| Consultation Response from Mark Berry KC, Highways Development Management |
| 2023/91454 Helm Farm, Colnebridge, Bradley, Huddersfield, HD5 0PU |
| Conversion/demolition and restoration of former agricultural building to form 5 dwellings erection of new garages to serve plots 2-4 and extension to plot 5 |
| Date Responded: 16-4-2024. Responding Officer: Mark Berry. Responding Ref: 10-2SW-3. |

DRAWING TITLE  
ACCESS PROPOSAL

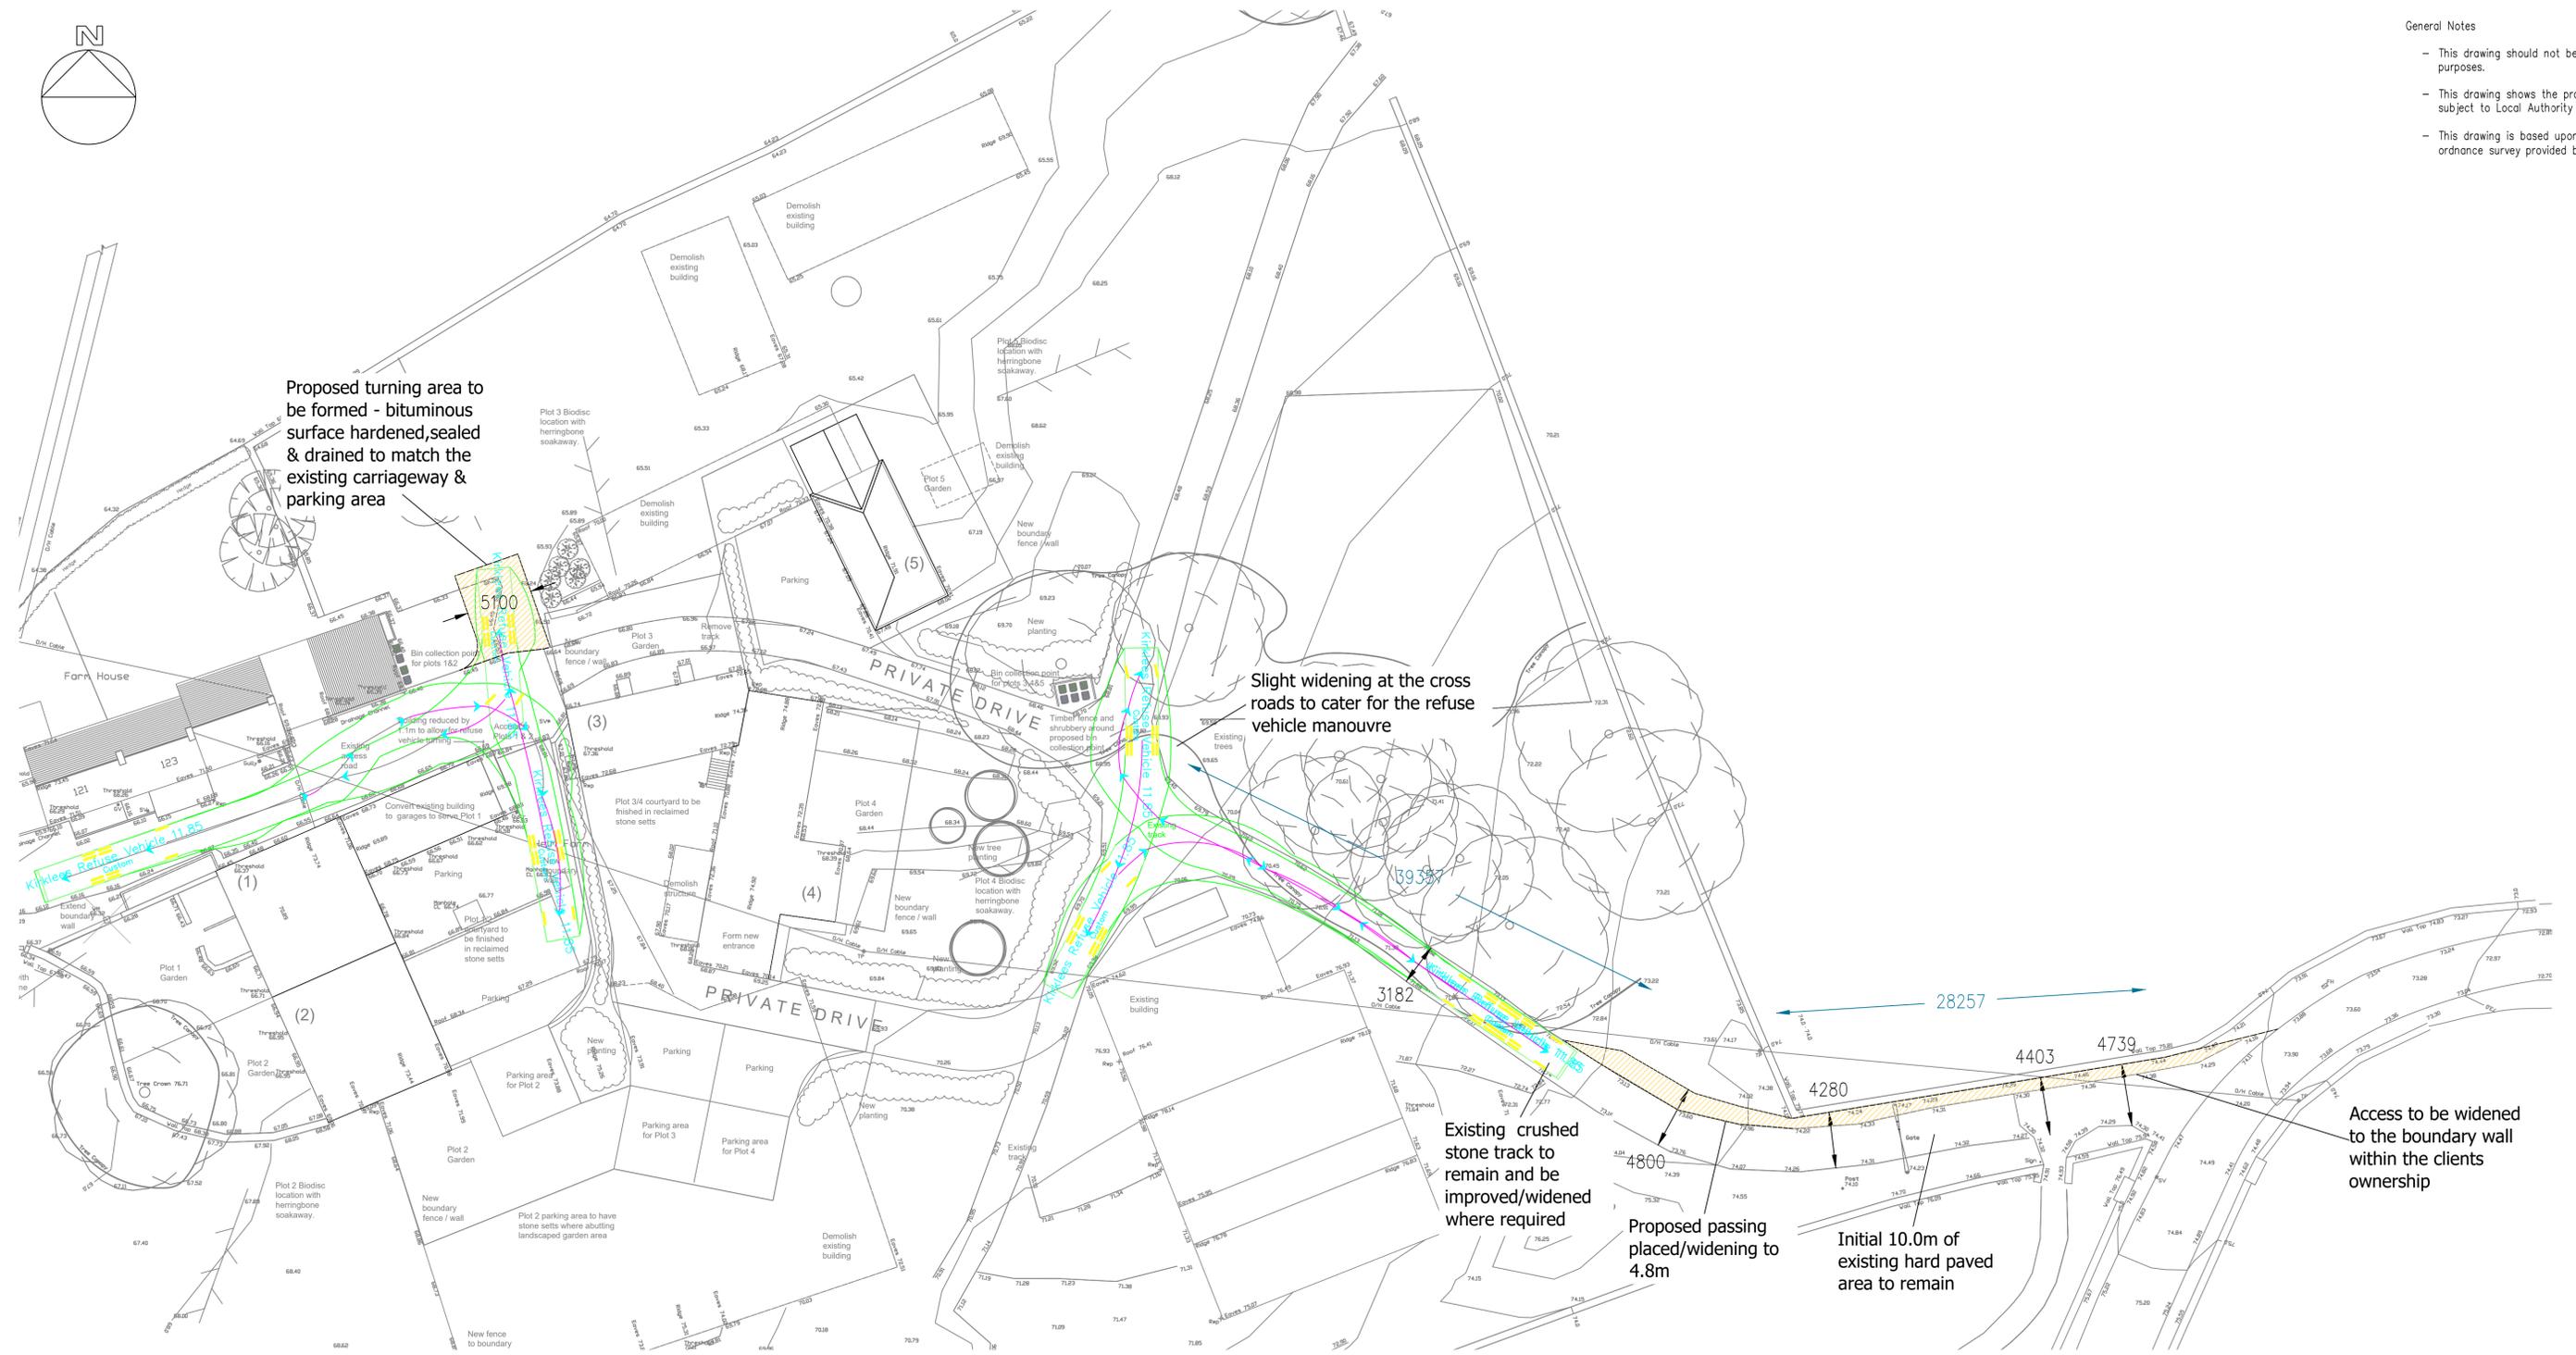
The refuse vehicle swept paths run over an existing parking area and an un-made grassed area. Can the applicants provide more detail of the layout and construction of this turning head.

The first 10m of the access from Paul Lane/Helm Lane is hard paved but no information is provided to say what the construction of the track is beyond 10m up to the proposed housing. Are these tracks considered to be fit for purpose in their current state or are improvements proposed.
